**Re: St. Margaret's Recycling & Transfer Centre Ltd, Sandyhills Planning Reference SU06F.321466**

I refer to the planning application ABP No: 321466 which were submitted by Saint Margaret's Recycling & Transfer Centre Limited, and I have a number of observations to make on the matter.

Figure 3.2 Evolution of planning history and development on site

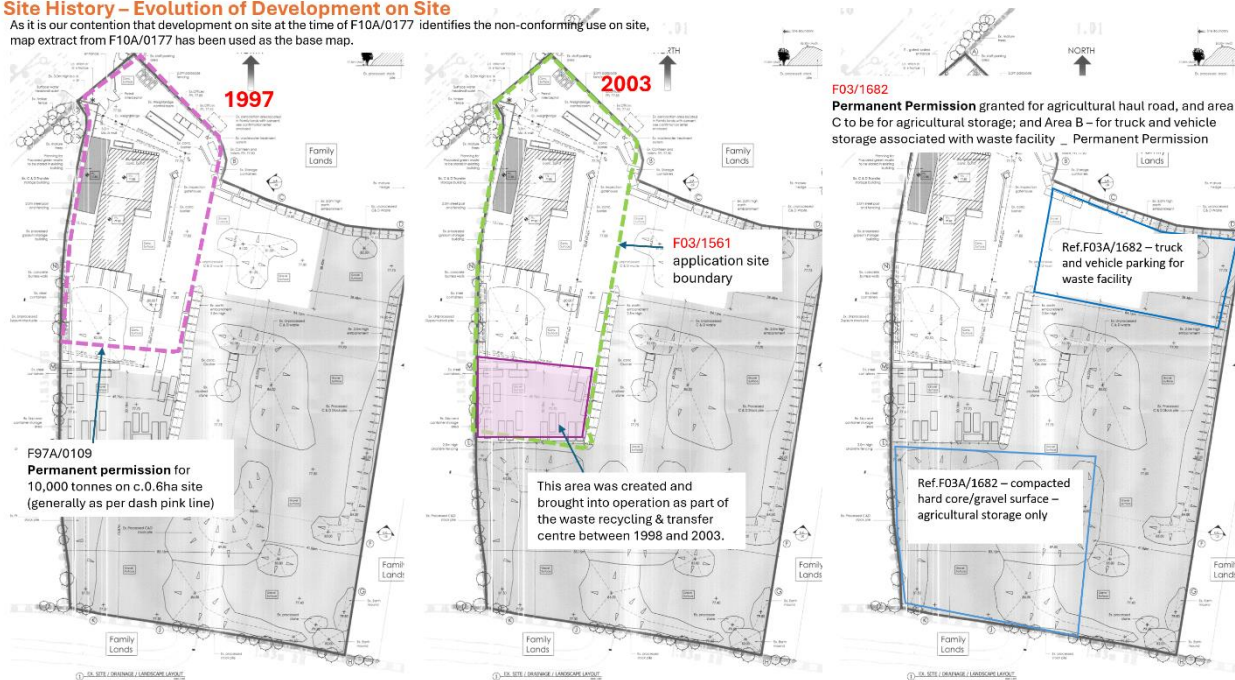
In figure 3.4 Unauthorised development.

The information provided refers to machinery comprising of hammermill, shredders and balers on site since 1995 in the position noted on the drawing. This is not correct please see attached Google Maps satellite photographs: **Exhibit 2**

The tilters alluded to on figure 3.4 were introduced post 2013 for turning containers (40 foot) for loading scrape, so we're not on site in 1995. The information provided in this section is false.
